From: Place Services Ecology [REDACTED]
Sent: 13 June 2022 11:48
To: Planning.Responses <Planning.Responses@arun.gov.uk>; Anita Gardner <Anita.Gardner@arun.gov.uk>
Cc: Sue Hooton - Principal Ecological Consultant [REDACTED]
Subject: F/5/22/DOC Wicks Farm Ford FIR

Application: F/5/22/DOC
Location: Wicks Farm Ford Lane Ford BN18 0DF
Proposal: Approval of details reserved by condition imposed under F/7/21/PL relating to conditions 3-surface water drainage scheme, 4-discharge of flows to watercourses, 5-maintenance and management of surface water drainage, 6-landscape screening scheme, 7-contamination and 9-ecological enhancements.

TITLE Proposed Site Layout Plan
 14/06/2022
 SCALE 1:2000 @ A3
 PROJECT No. 23482
 REPORT TYPE
 DATE 03

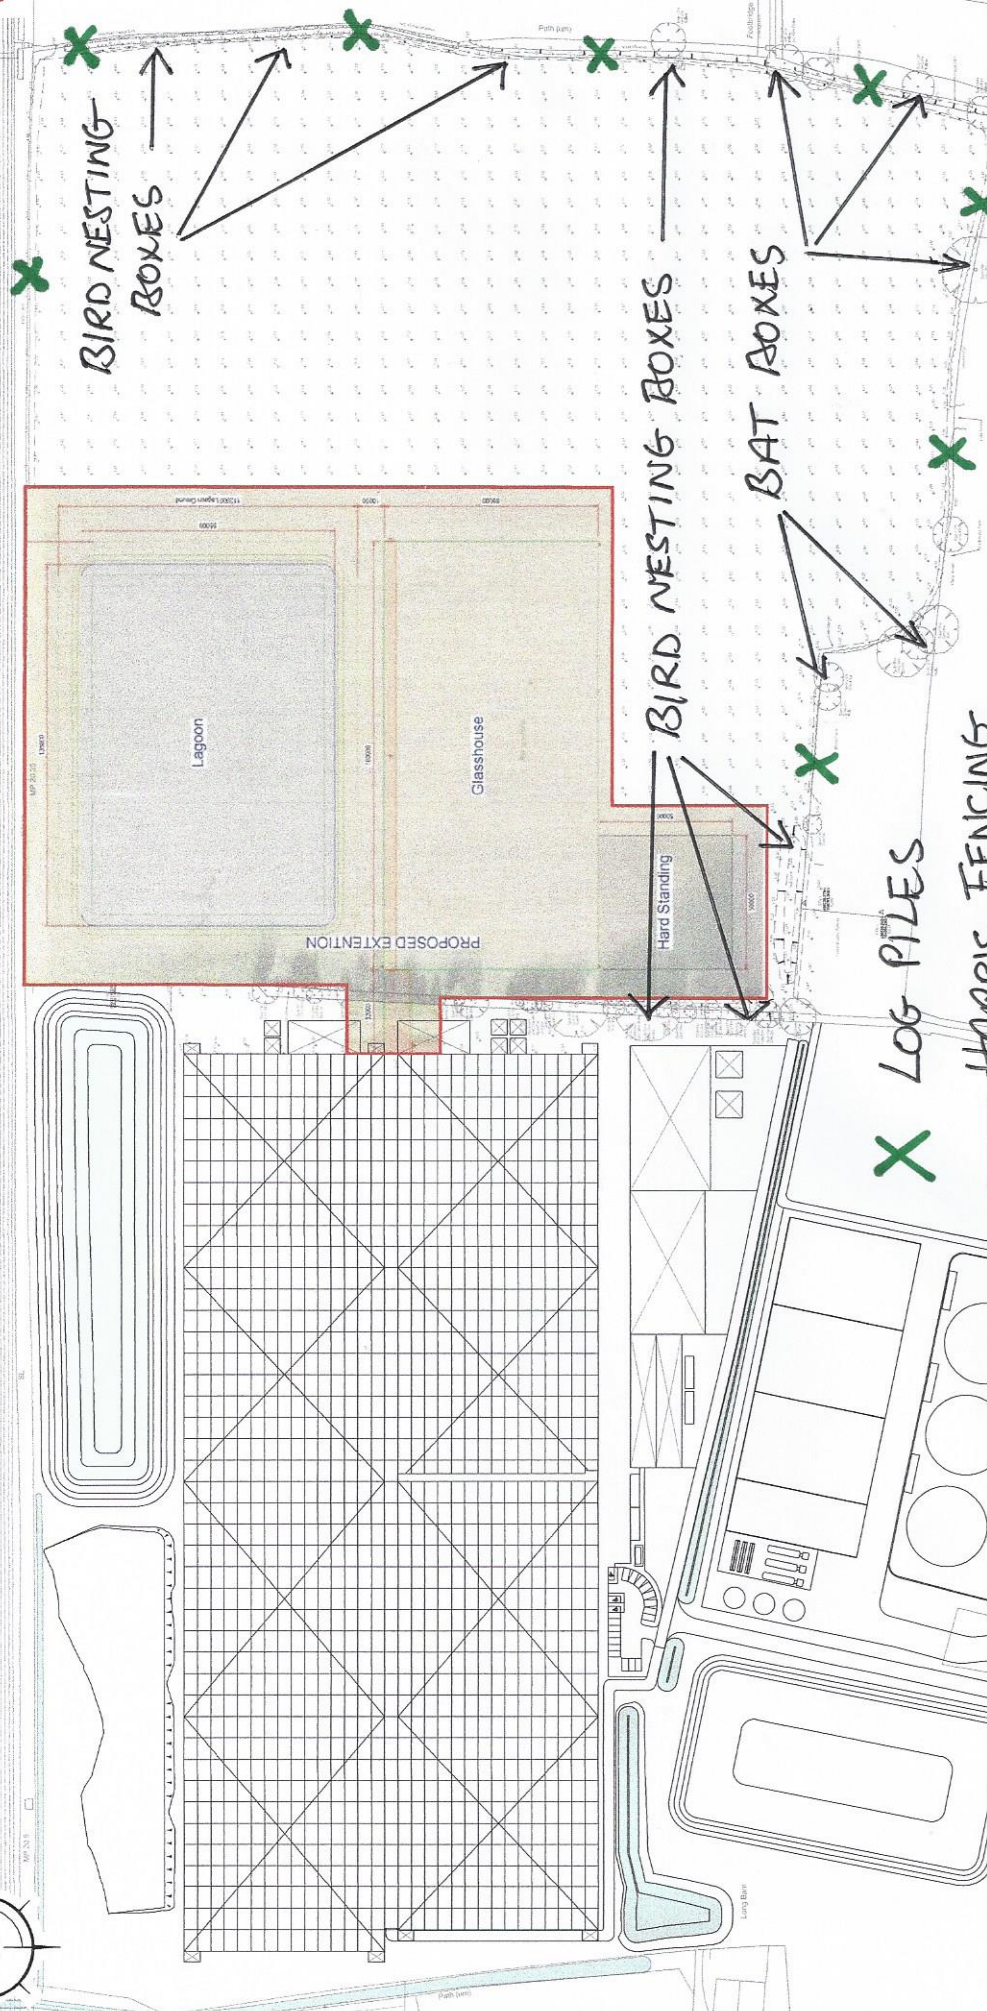
With regard to Condition 9, please can you confirm to John Hall Consulting Ltd., that a plan of the locations of the Harris fencing, bird and bat boxes and log piles is required, as suggested in the letter attached to the above application.

Please can you also request that the design of the bat and bird boxes is confirmed as required by Condition 9:

- *Position and design of a bat box to be installed on the trees onsite facing south/south westerly positioned 3-5m above ground.*
- *Position and design of a bird box to be installed on a tree on the site.*
